From: Glenn Travers <glenn.travers@arun.gov.uk>
Sent: 30 November 2021 17:33
To: Richard Sherman <Richard.Sherman@arun.gov.uk>
Subject: Re: BE/101/21/HH - 3 Homing Gardens, Bersted

We are looking over your application for 'Replace metal framed/wood panel workshop in rear with brick-built workshop (This application may affect the character and appearance of the North Bersted Conservation Area) at the above address.

extending homes Tel:- 01243 555208 enquiries@extendinghomes.co.uk	
TITLE:- Outbuilding @ 3 Homing Gardens North Bersted West Sussex PO22 9AJ	
DATE:-	2nd September 2021
SCALE:-	Elevations Scale 1-100 on A2 Paper
DRAWN:-	P.Robinson
DWG. No. 2021078/PL/1

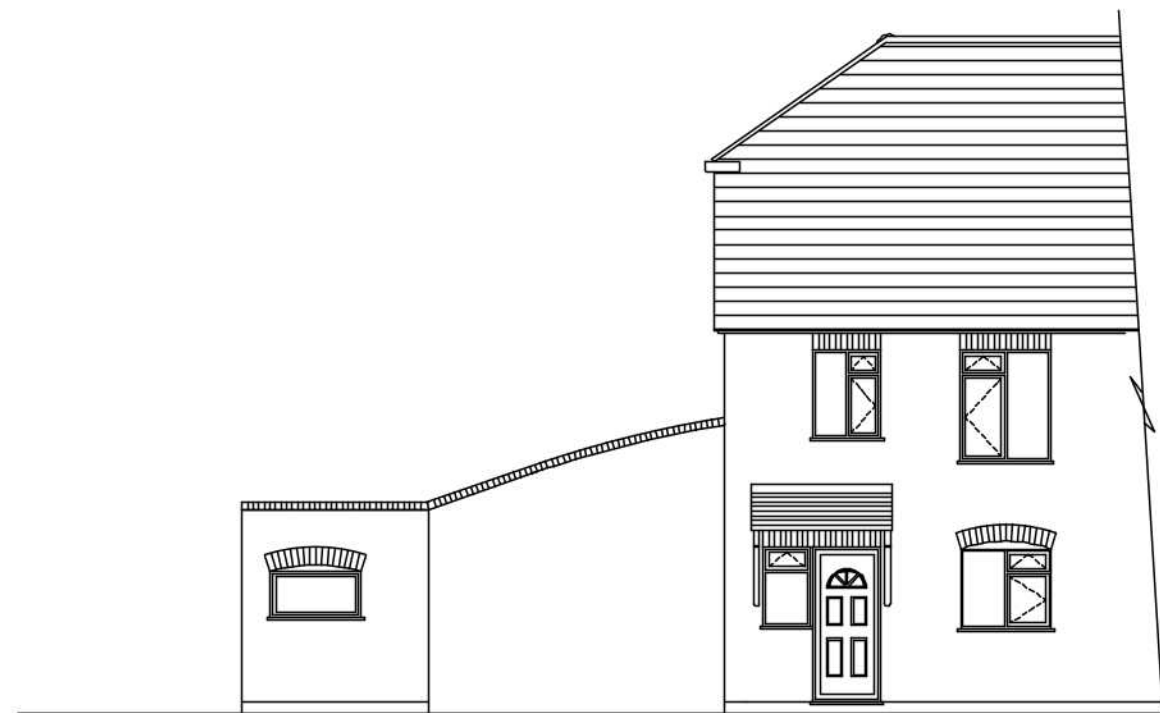
However on the Proposed Elevations plans you have submitted, they have been labelled incorrectly as 'Existing and Proposed NEE' and 'SWW' Please see snapshot below:

Therefore please can you amend these and resubmit these plans to me as they are supposed to be NNE and SSW?

Attached are new PDF's. 1B, 2B and 3A. Responding to No. 7s comment about linking to his wall, I have revised to show totally separate workshop.

DWG. No. 2021078/PL/3

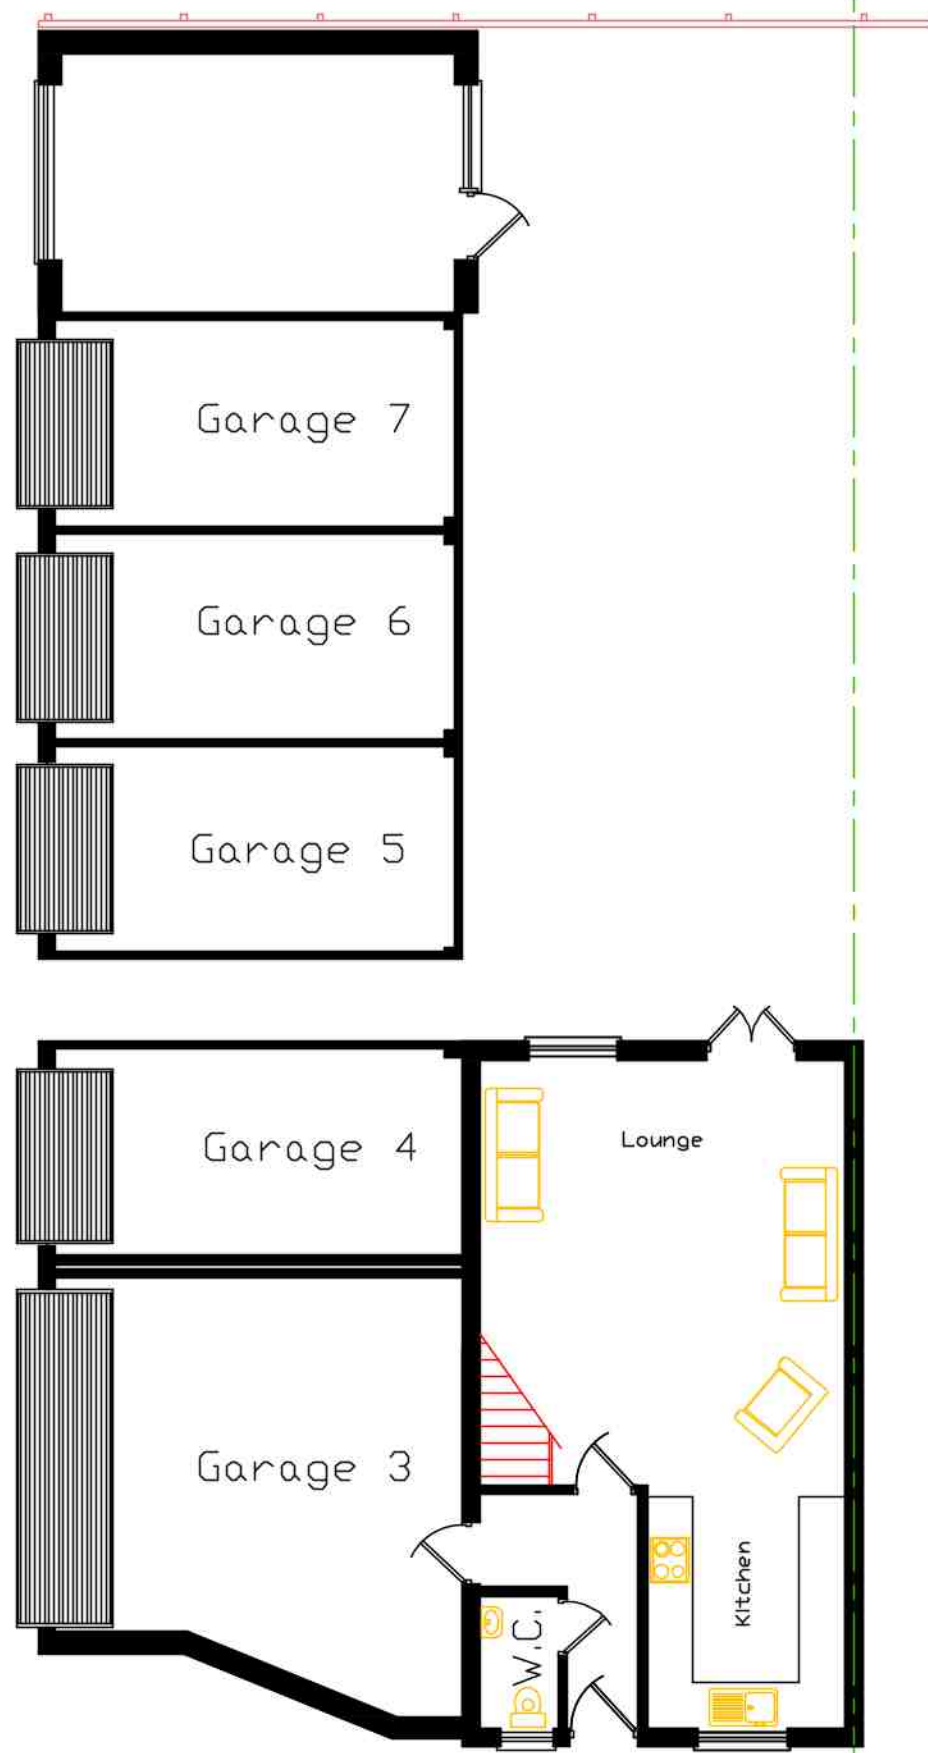
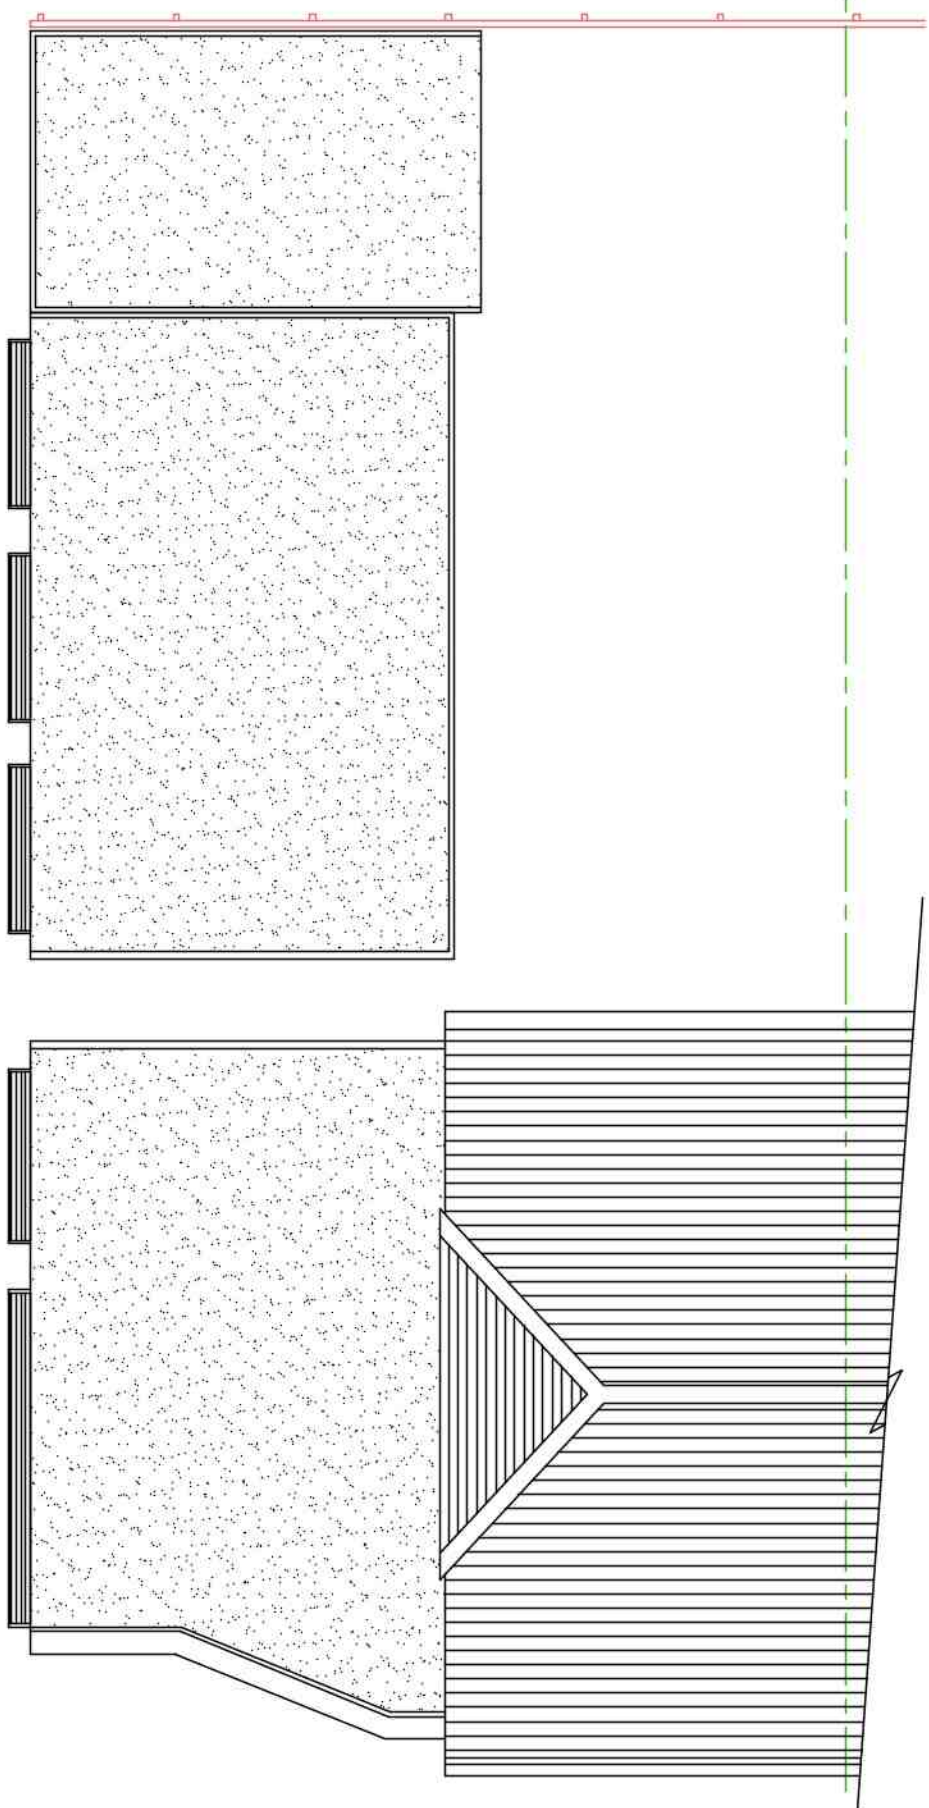
Also please can you re-submit a new roof plan as the one you have submitted cuts off the bottom section as below:

Please find attached as requested
